KITITAS COUNTY

DEPARTMENT OF PUBLIC WORKS

MEMORANDUM

TO: All Staff
FROM: Public Works Plan Review Team
DATE: May 12, 2025
SUBJECT: BL-25-00007 Curley Miller

PREPARED FOR DON MILLER SECTION 4 AND SECTION 33 TWN. 19 N., RGE. 15 E. AND TWN. 20 N., RGE. 15 E., W.M. KITTITAS COUNTY WASHINGTON		
DWN BY <b>E.Z./G.W.</b>	DATE <b>06/2025</b>	JOB NO. <b>230052</b>
CHKD BY <b>D.L.P.</b>	SCALE <b>1" = 200'</b>	SHEET <b>1 OF 2</b>

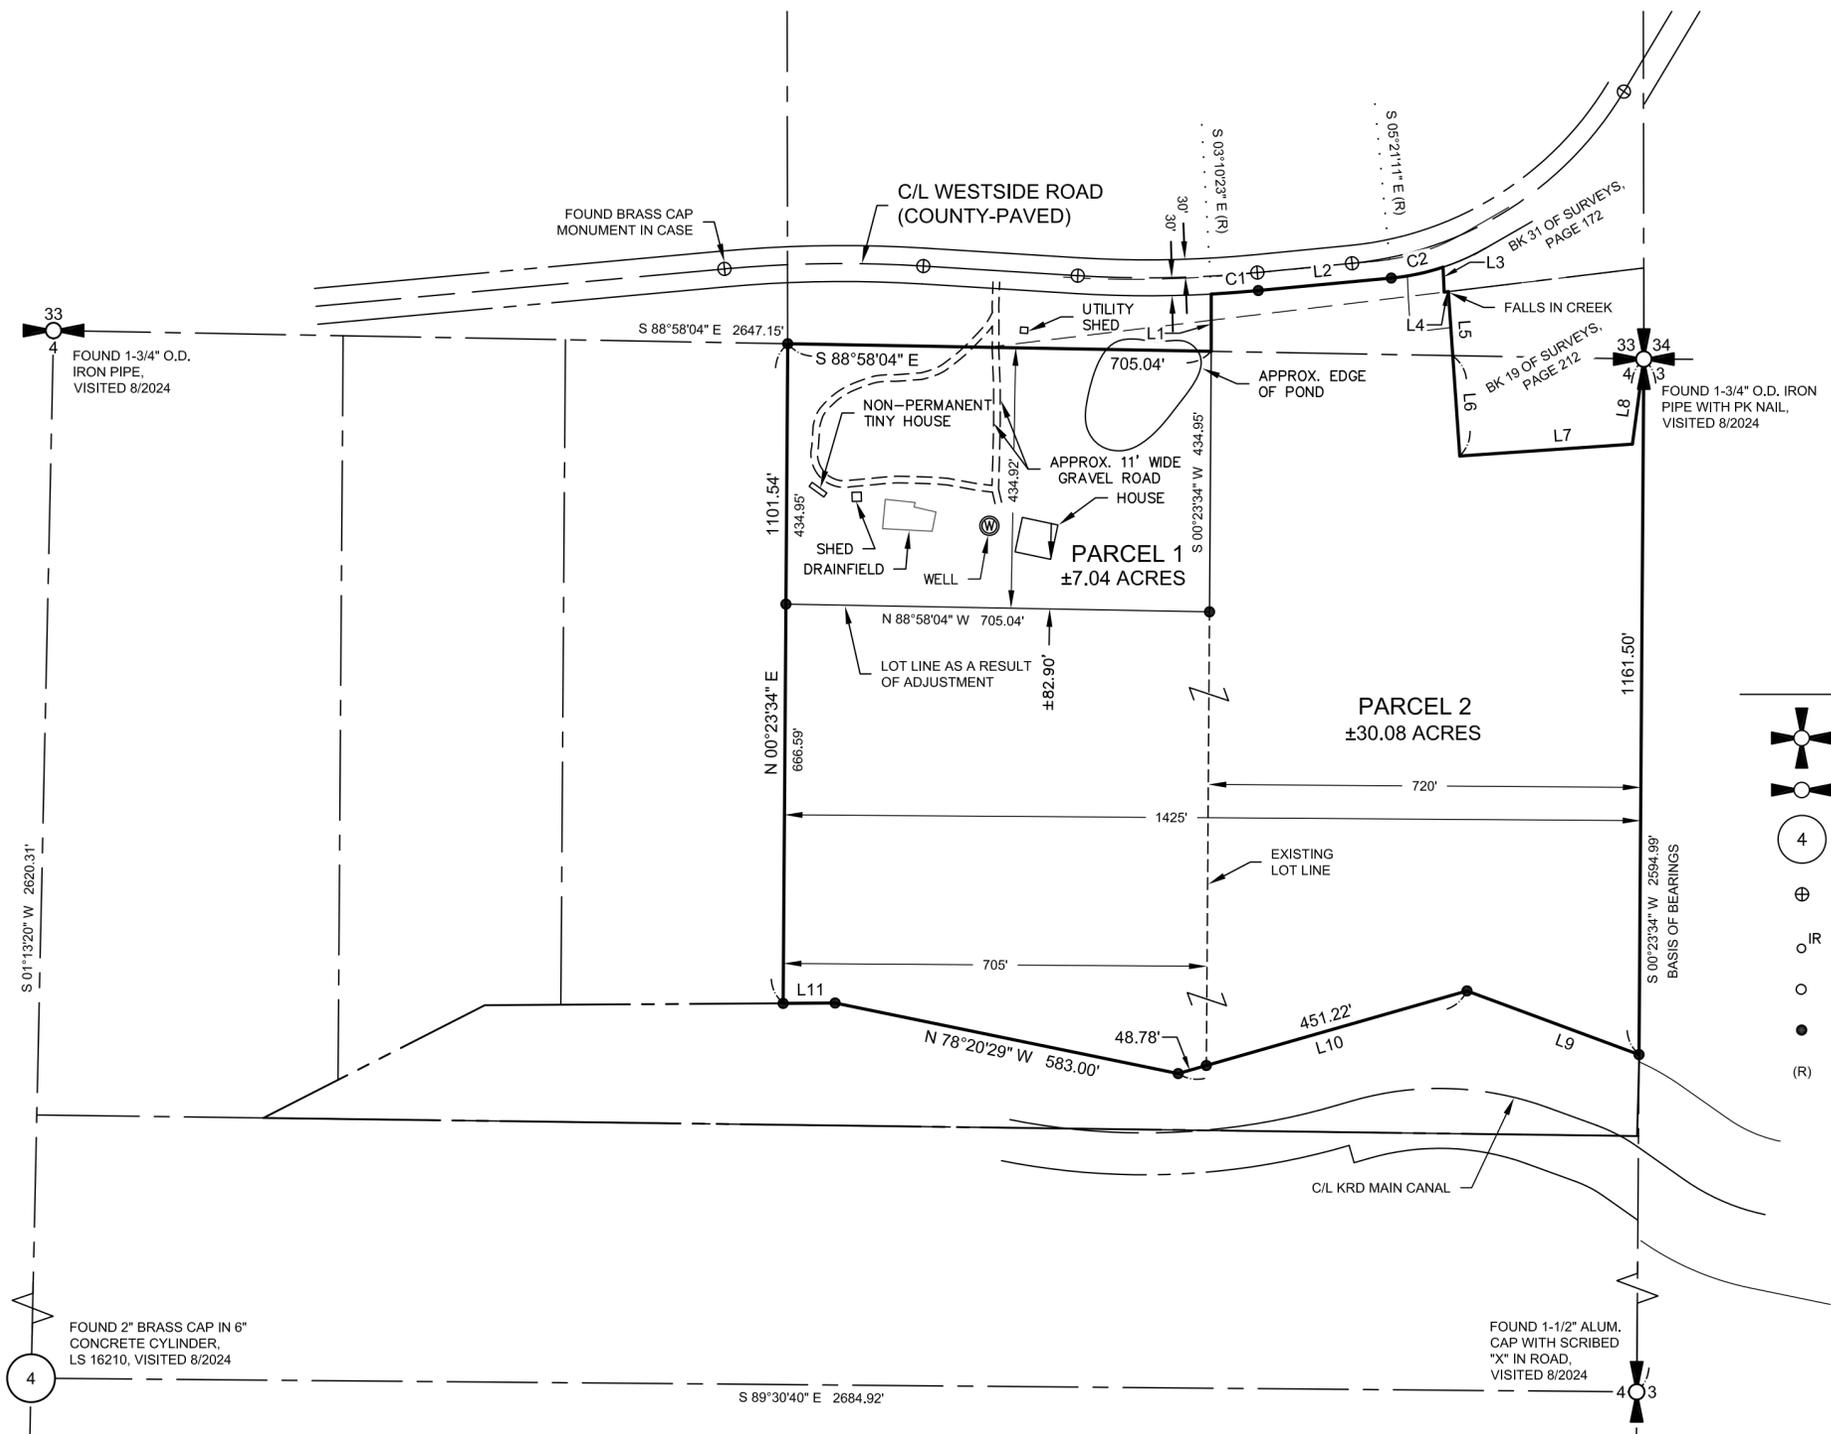
SURVEY	<ol style="list-style-type: none"> 1. Please note or show Basis of Bearing. 2. County Road should include surfacing, and ownership (paved county r/w). 3. Please show the body of water located near the NE corner of Parcel A. While KCC:16.24.060 calls out a meander line, it would be acceptable to depict the location of the edge of water. This does not need to be survey accuracy. 4. There is an erroneous setback distance shown located south of the house on Parcel A. (JT)
TRANSPORTATION CONCURRENCY	No transportation concurrency application is required for this project. (KAH)
FLOOD	Parcels 015534 and 022534 are not within a FEMA identified special flood hazard area (100-year floodplain). A floodplain development permit is not required for the project. (SC)
